Redevelopment of Harbourside Shopping Centre, Darling Harbour (SSD-7874-Mod-2)

Thank you for your correspondence via the Major Projects Portal on 14 April 2022, requesting Transport for NSW (TfNSW) to comment on the above.

Image 114 Basement access, and Darling Drive drop off locations

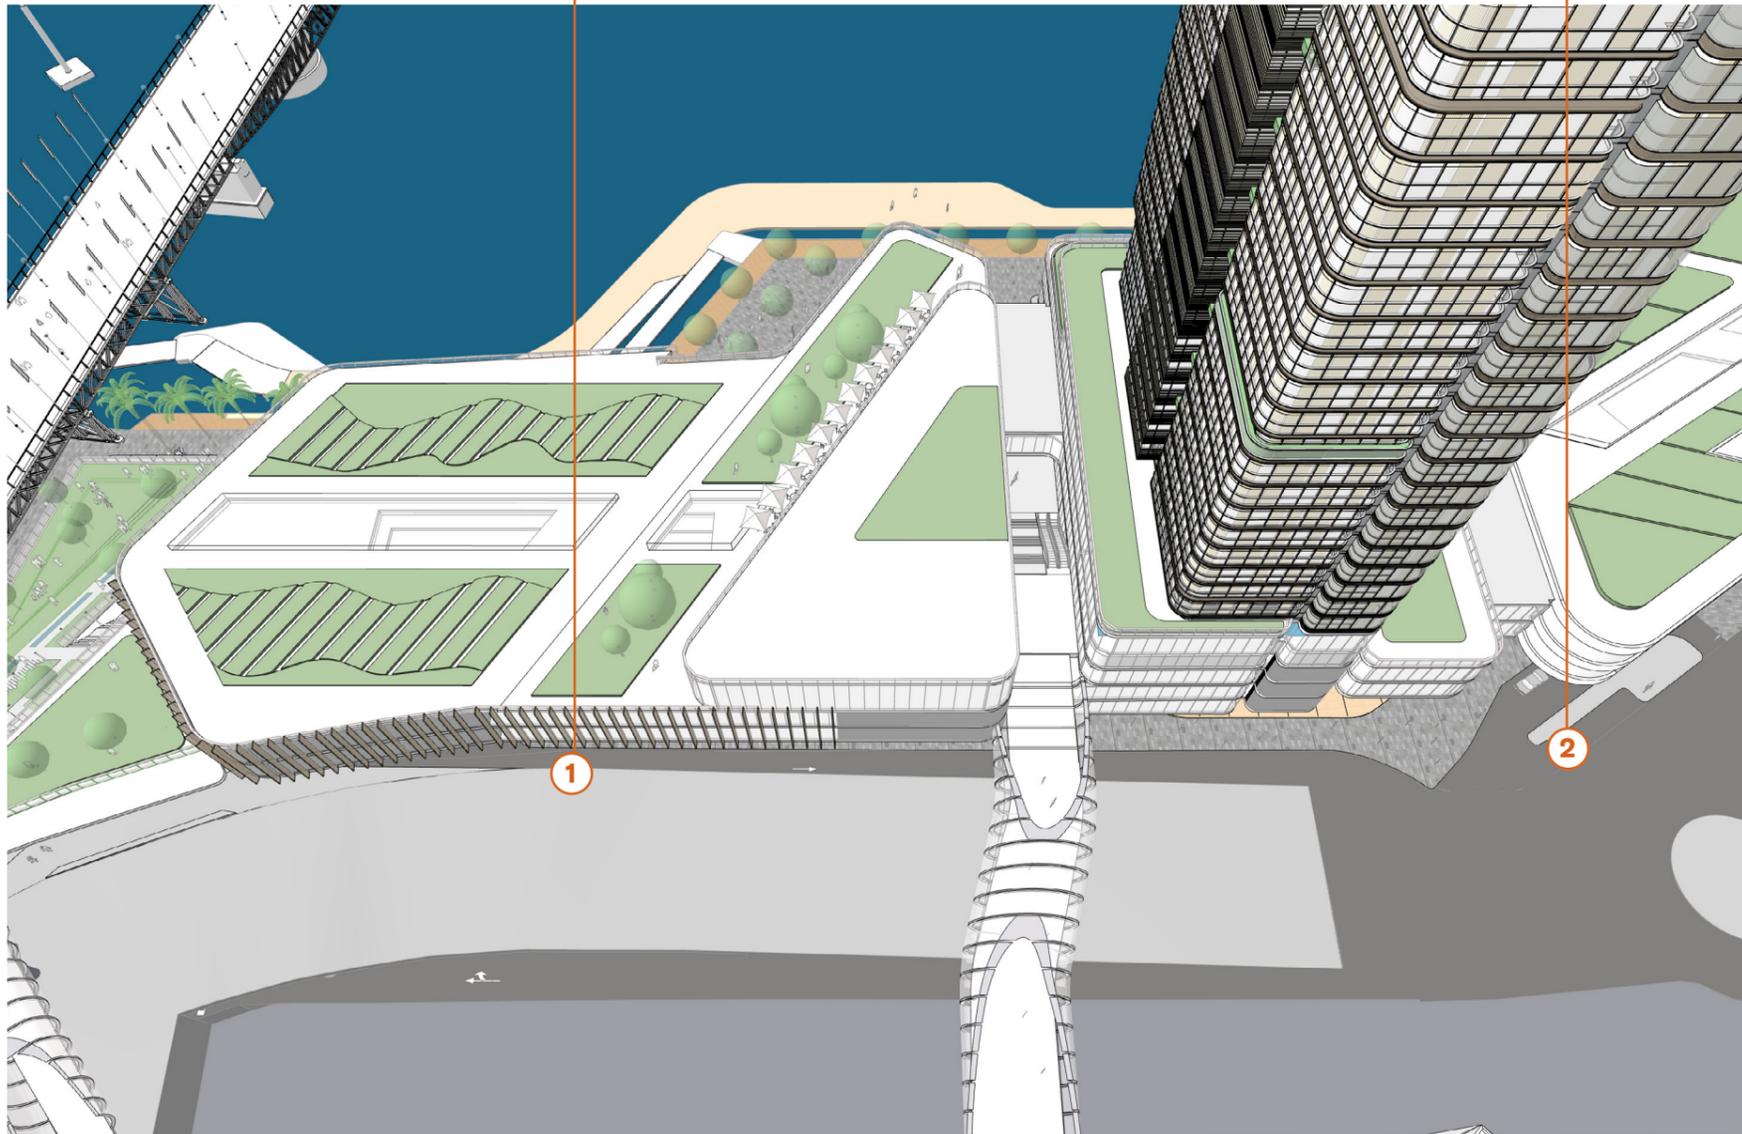
TfNSW acknowledges that the above modification proposes additional car parking of 30 spaces for the commercial component of the proposed development compared to maximum parking of around 250 spaces allowed based on the Sydney Local Environmental Plan 2012 (SLEP 2012). However, it is noted that the proposed development is at a location where:

- High levels of existing public transport facilities are provided; and
- The proposed West Metro Pyrmont Station is located within 400m of the proposed development.

A reduction of parking would encourage workers to use active and public transport in particular the future Sydney West Metro.

It is suggested that the proponent reduce the proposed amount of car parking.
